Project Name: AMERICAN SQUARE

DATE: May 17, 2013
TO: Jack Cloud, DRB Chair
FROM: Catalina Lehner, Senior Planner *CLL*
RE: Project #1008124, Murphy Oil- American Square SC
Site Development Plan for Subdivision Amendment and
Site Development Plan for Building Permit

Staff reviewed the April 18, 2013 version of the site development plans and finds the following regarding the site development plan for building permit:

TRASH ENCLOSURE DETAILS

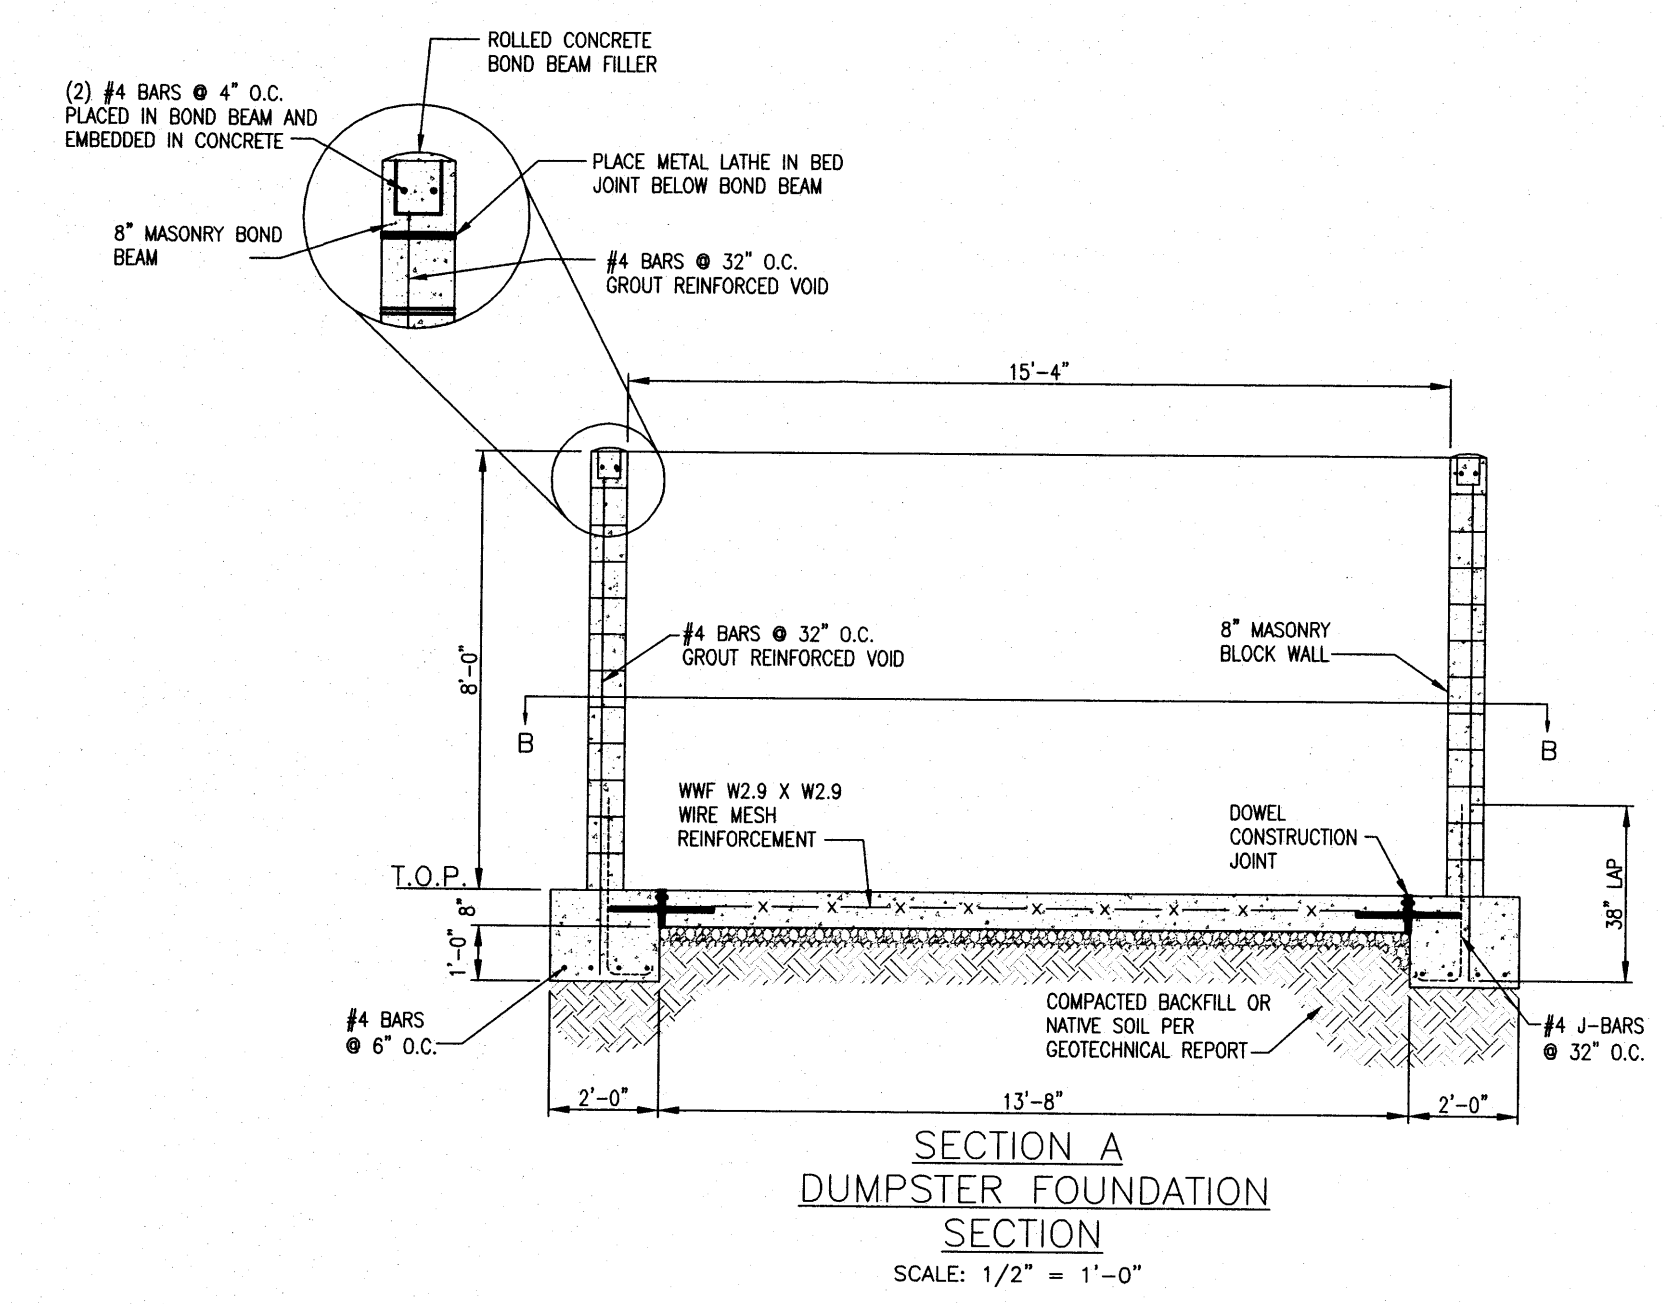
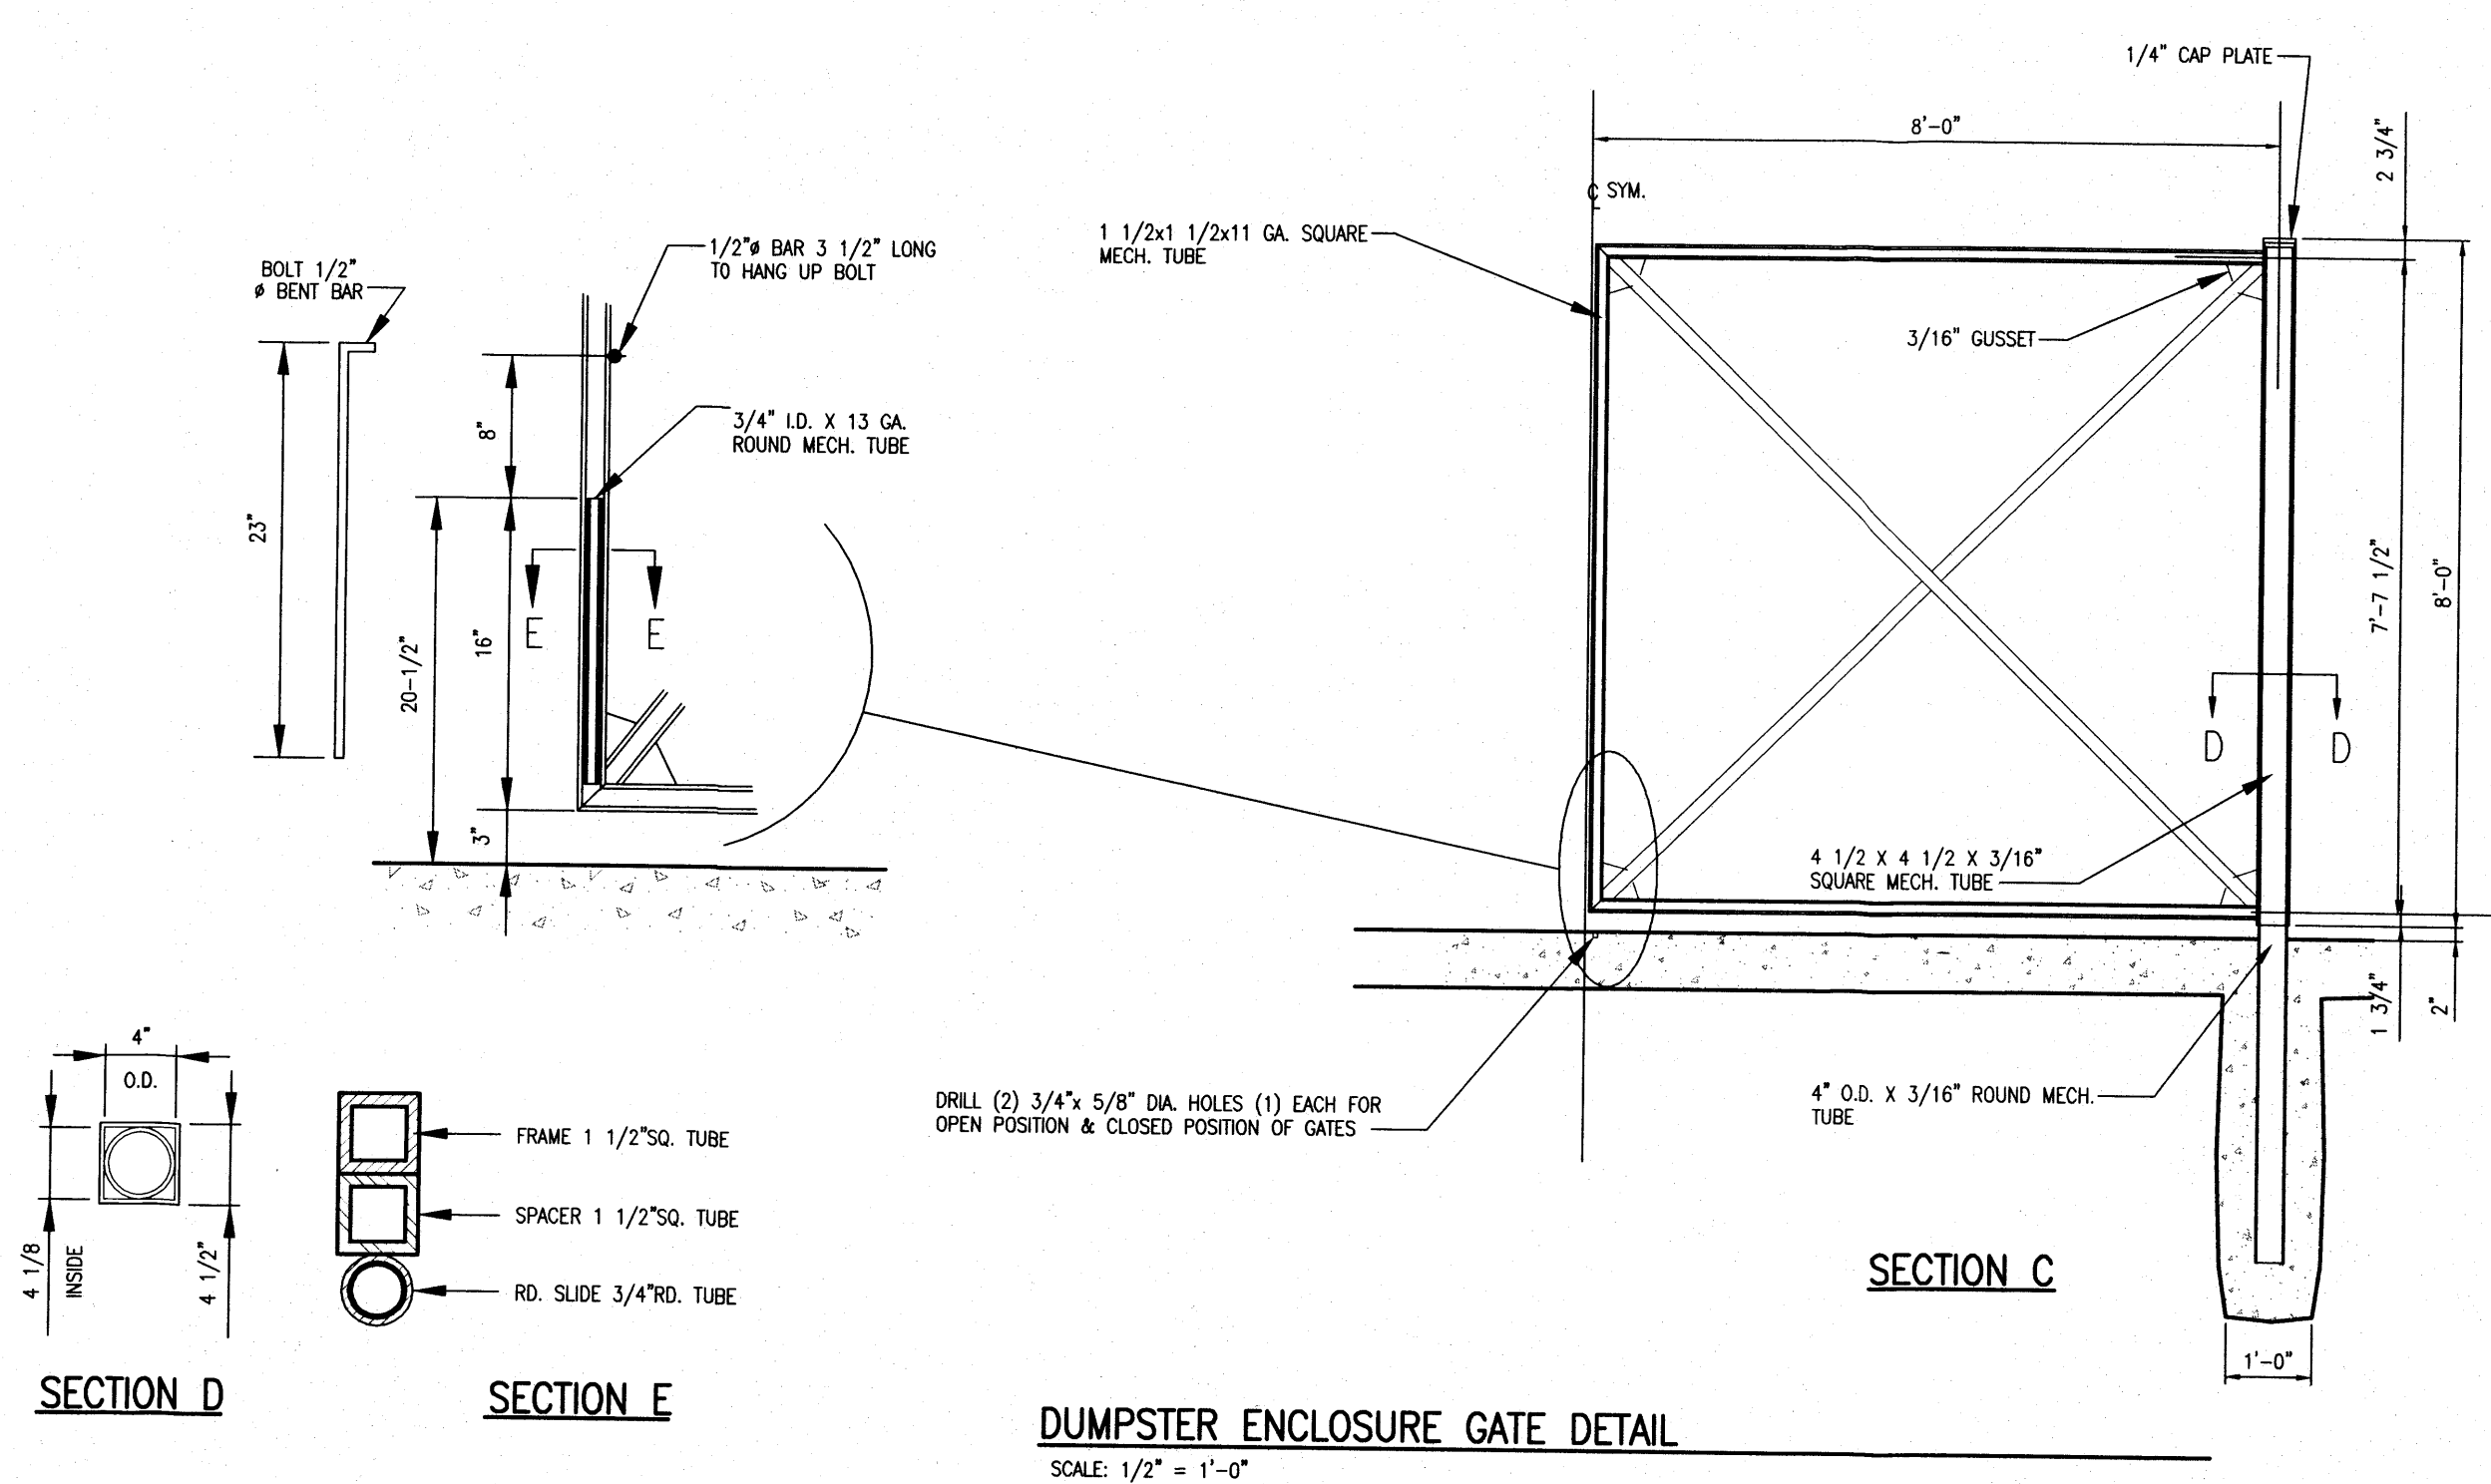
Condition 6D: The refuse enclosure shall be constructed on split-faced CMU. The condition doesn't call for brick veneer and a color change.

Front Elevation (East)

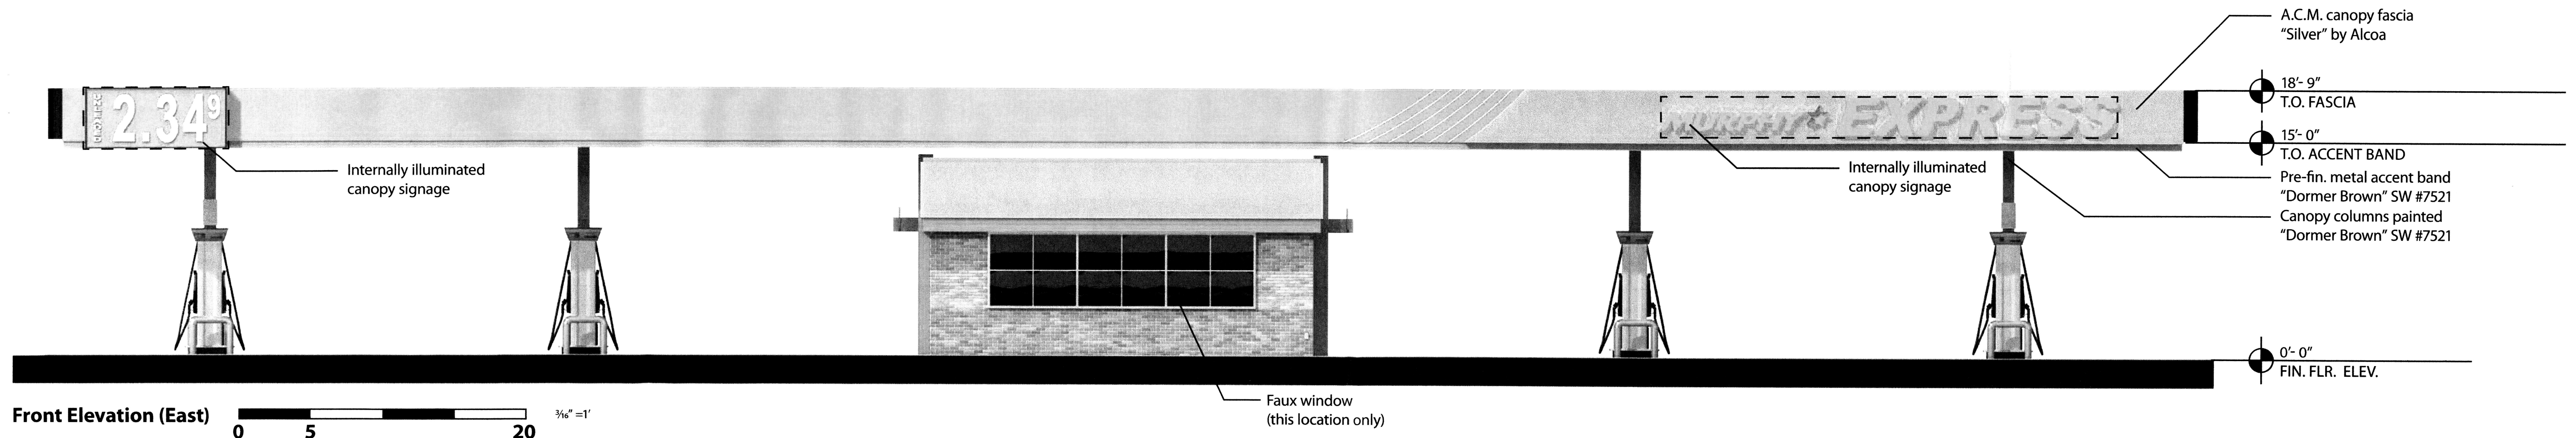
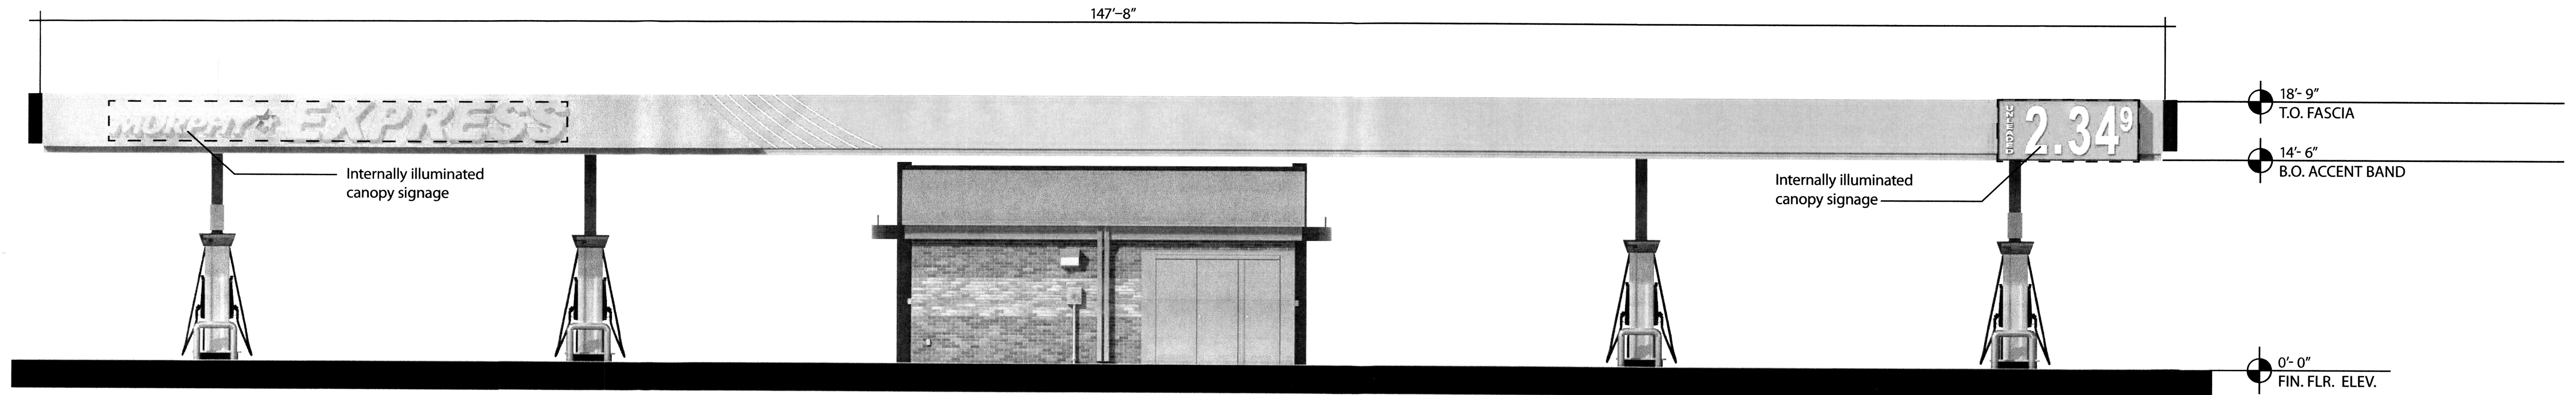
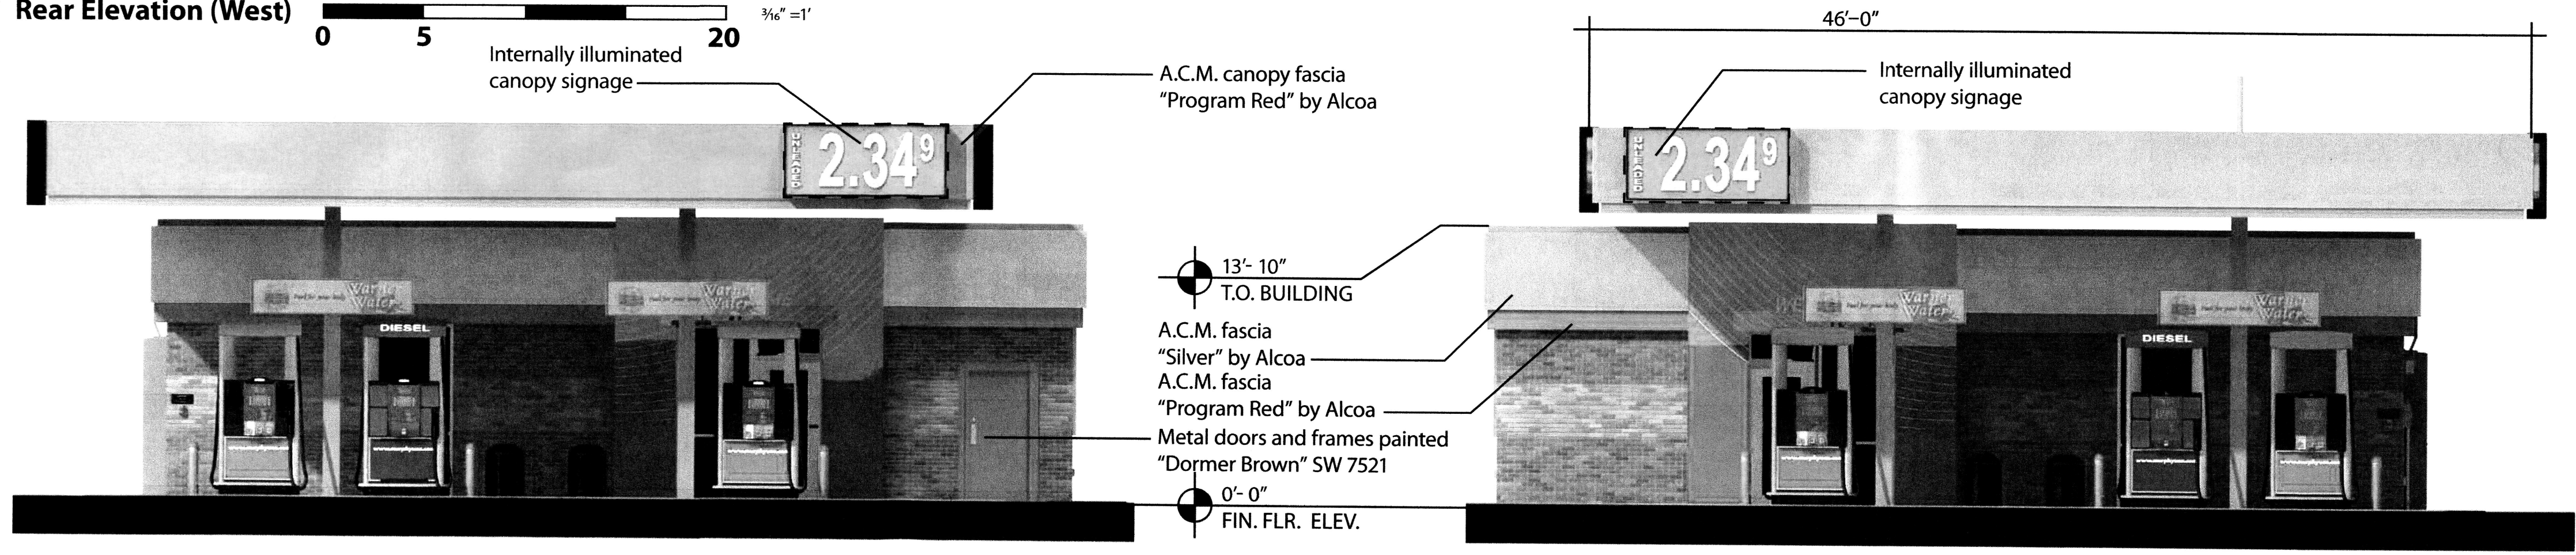
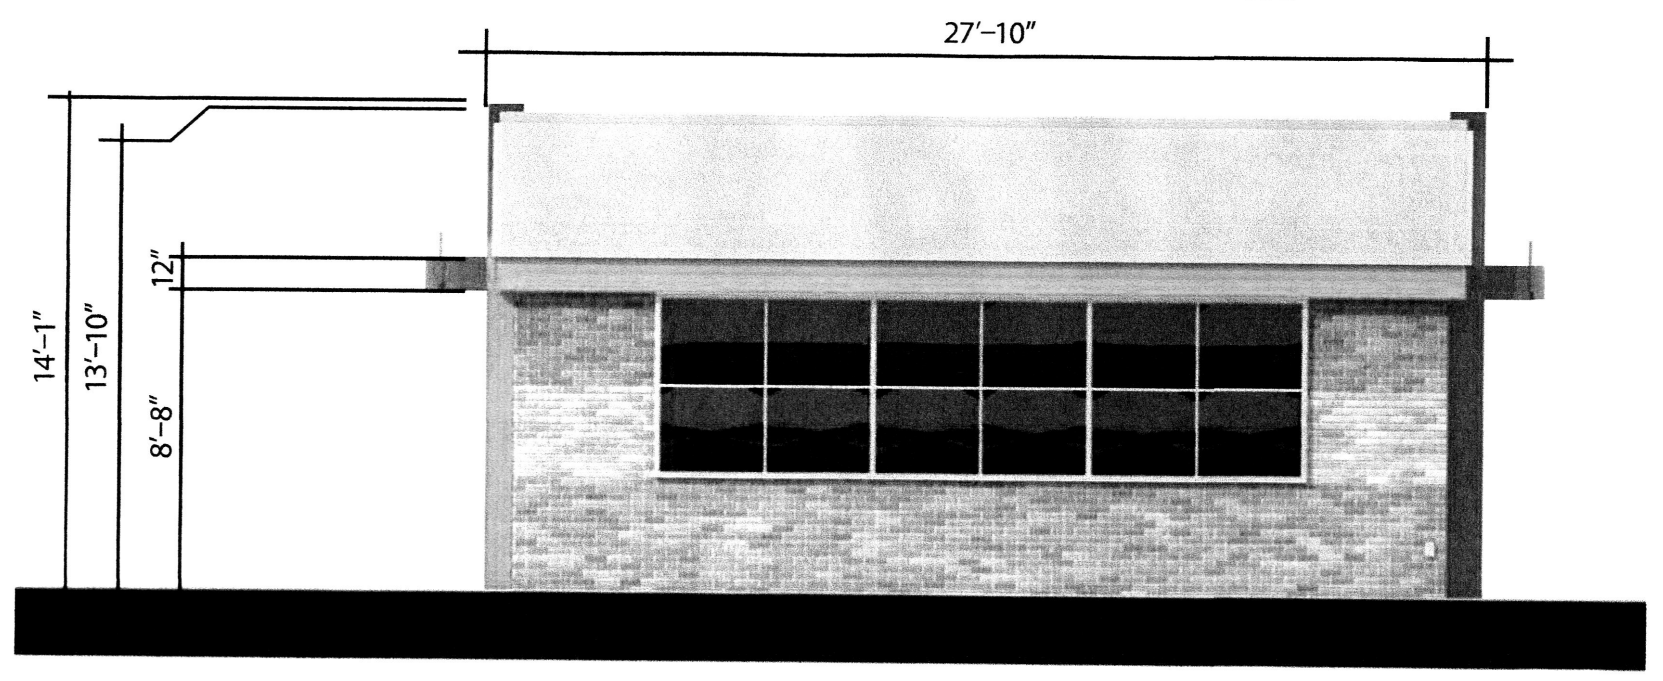
Condition 5B: The color (white) of the building-mounted Welcome sign still needs to be specified on the elevations (note: it won't copy so the note is needed).

Condition 6A: The scale is now specified as 3/16, which is all that's needed. The bar scale on the elevations is confusing and should be removed, especially since it scales out to 19 feet instead of 20 (it's "off").

Condition 6B: The color legend was not re-instated but needs to be.
